Date: 15-Apr-2026
Our Ref: 2026/90780

**Application for a non-material amendment following a grant of planning permission,
Town and Country Planning Act 1990**

**Non material amendment to previous permission 2025/93073 for erection of first
floor side extension, hip to gable, dormer and associated works
7, Woburn Drive, Waterloo, Huddersfield, HD5 0AQ
Application Number: 2026/90780**

PROPOSED 1ST FLOOR PLAN

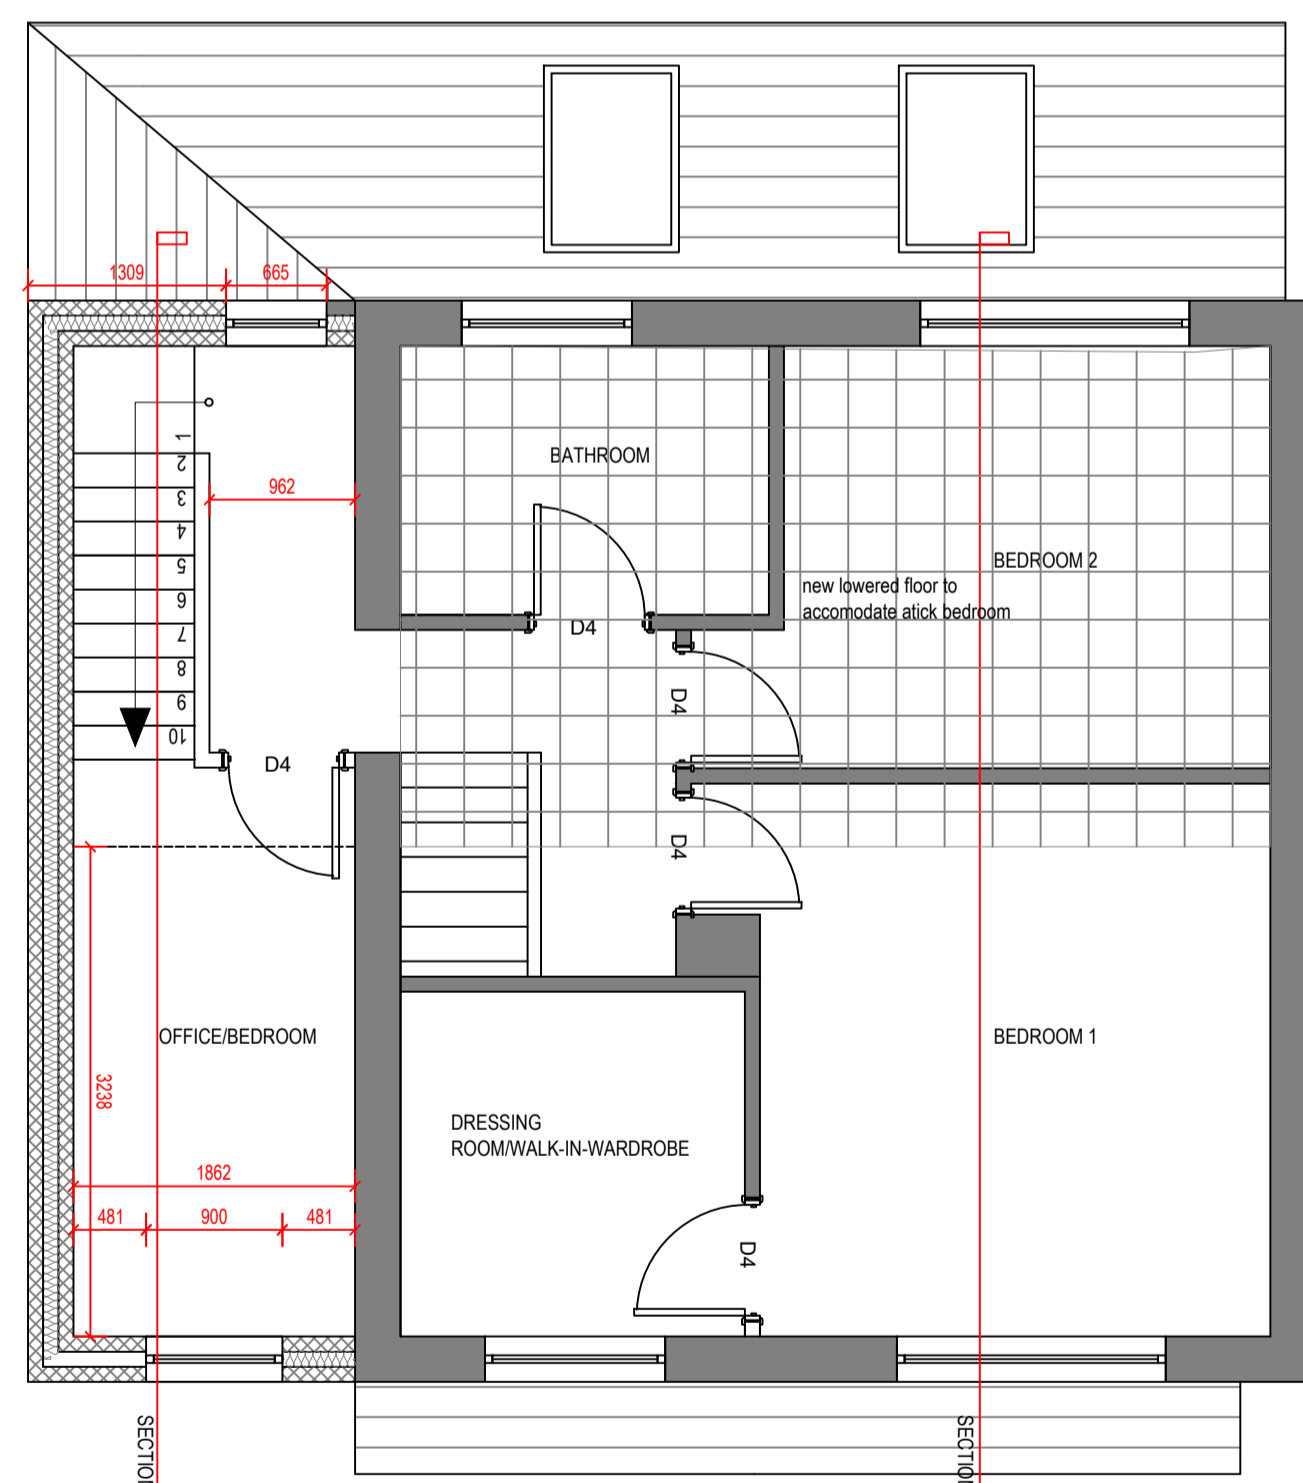
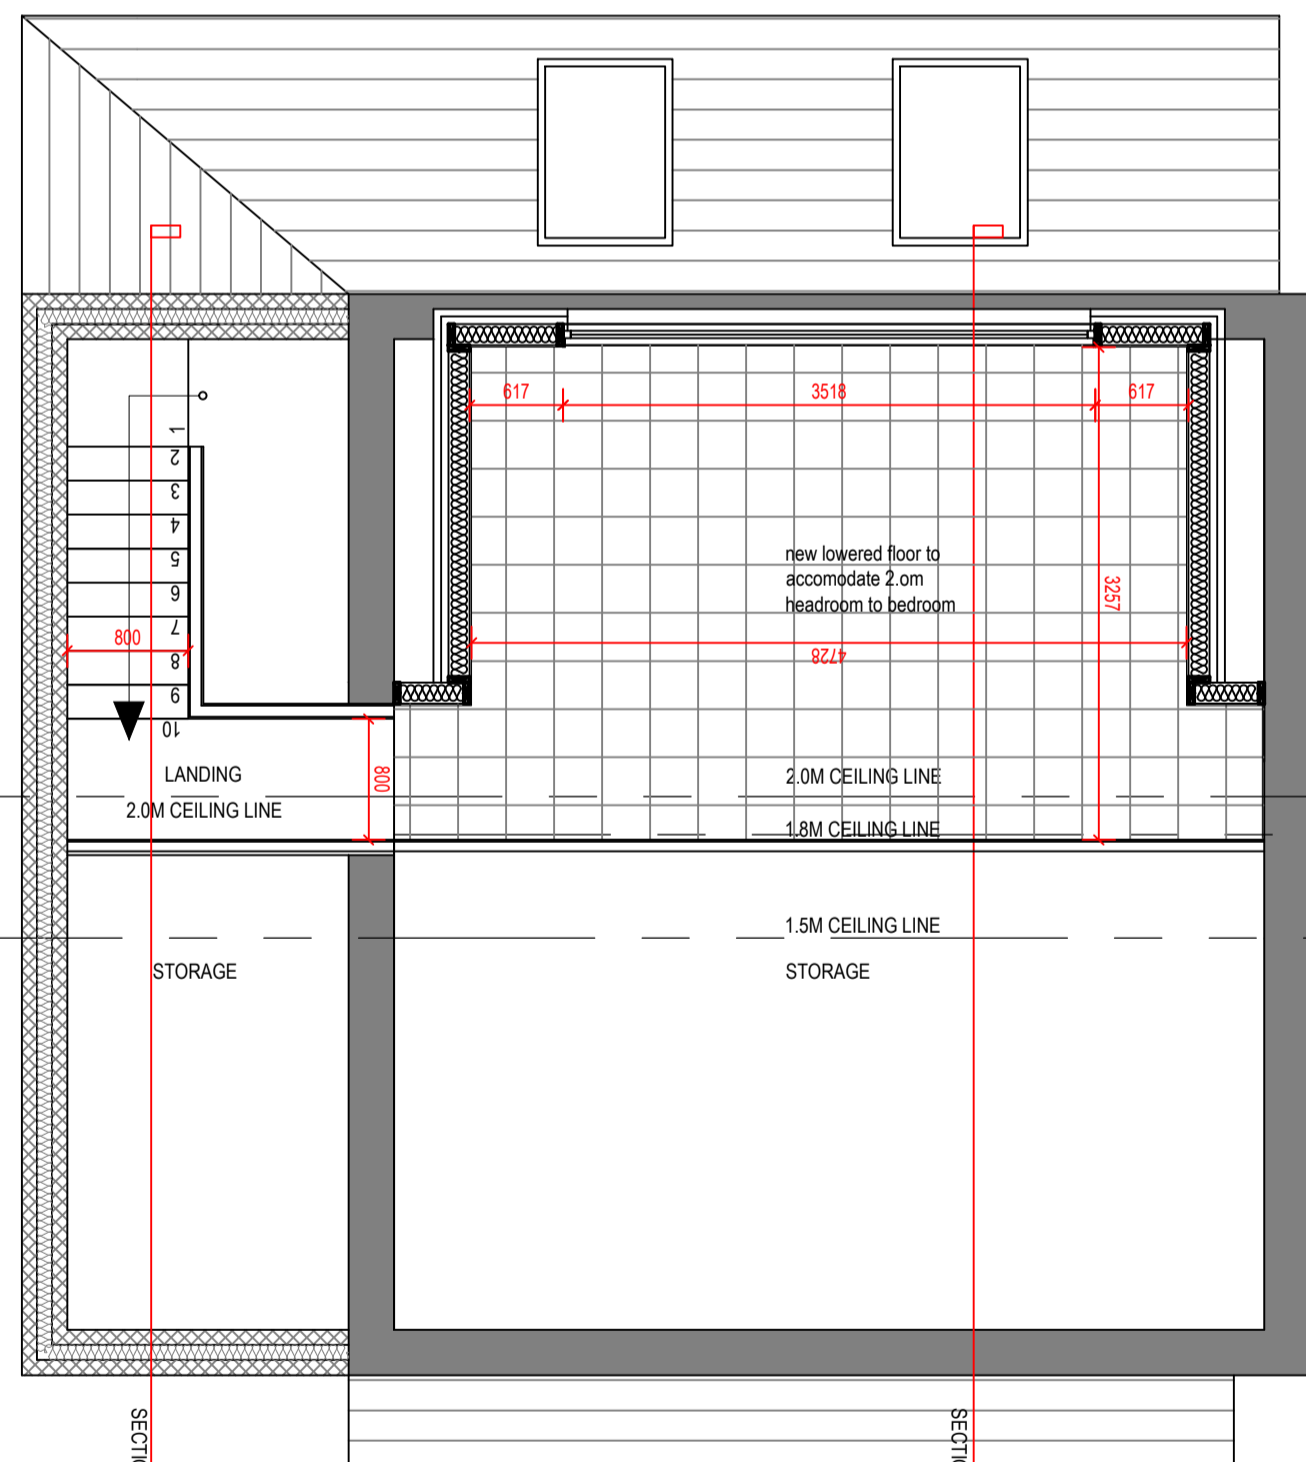
I am only able to consider non-material amendments to plans approved under a previous planning permission which are minor and do not materially change the appearance or character of the previously publicised scheme. The proposed alterations to the approved plans extend beyond this and hence I am unable to accept them. A new application will be required which will be subject to a further round of publicity and consultation.

The amendments shown on plan reference 2025-006(20)002 would not appear subservient to the host and contrary to current policy set out in the Local Plan and House Extensions and Alterations SPD.
